This is to certify that FERRARO MARGARET R Ferre Michaud  
has permission to New residential 2 unit 32' x Duplex  
AT 29-33 INVERNESS ST City 168 F008001

**City of Portland, Maine - Building or Use Permit Application**

Location of Construction: 29-33 INVERNESS ST	Owner Name: FERRARO MARGARET R	Owner Address: 37 INVERNESS ST	Phone:
Business Name:	Contractor Name: LeFerre Michaud	Contractor Address: 200 Riverside Ind Pkwy, Portland	Phone (207) 831-7427
Lessee/Buyer's Name	Phone:	Permit Type: Duplex	
Proposed Use: Duplex- New residential 2 unit 32' x 36' Duplex		Proposed Project Description: New residential 2 unit 32' x 36' Duplex

DRAWN BY: DMD/RTG
CHECKED BY: RTG
SCALE: 1"=20'
DATE OF SURVEY: 06/15/2006
JOB NUMBER: 2006060
SHEET: 1 OF 3

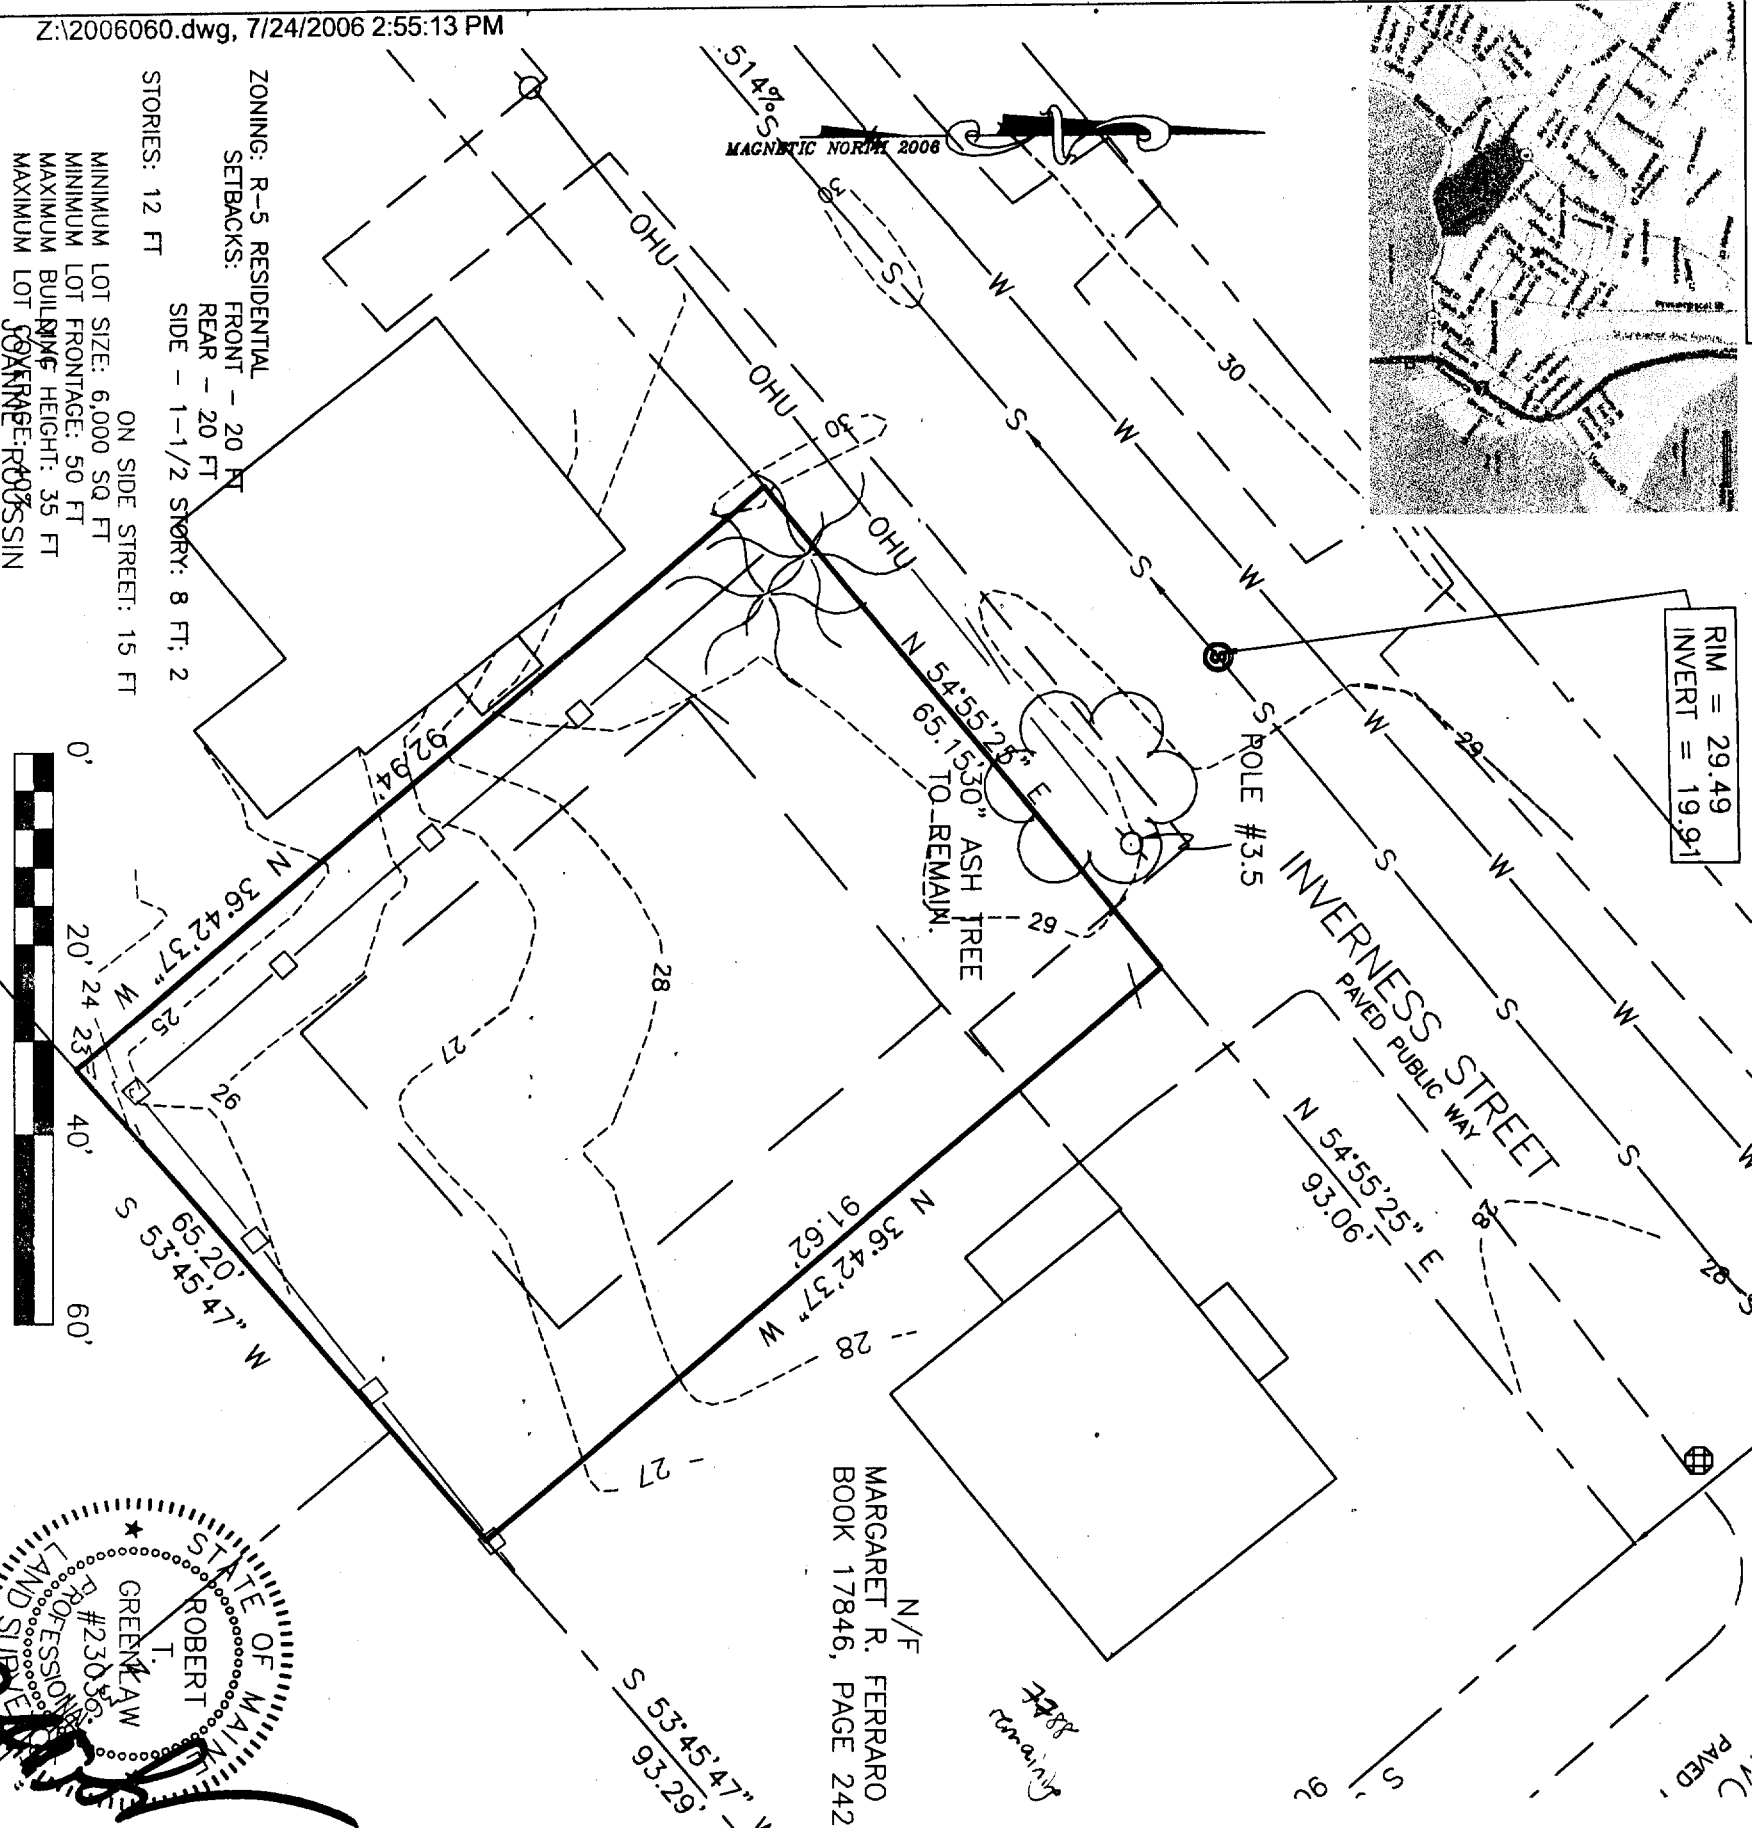
09/11/2006-mes: on 8/24/06 received revised plot plan which showed changes to the driveway (now not meeting the required 5' setback from side line) and did not show the reduced deck size. Today received revisions. Decks reduced, but one driveway is still within 4' of side line. Needs to revise that one problem.

2. The new driveways are not meeting the ordinance. It shows that the parking area going as close as 1.5' & 2' on the side yard within 50' of the front property line. It can't be closer than 5'.

8. The electric line will be installed underground as shown on the revised plans.
9. We have altered the driveways to reflect the desired width of proposed driveways while maintaining a 5-foot setback from the property line for the first 50 –feet. We hope the design will appease both requirements.
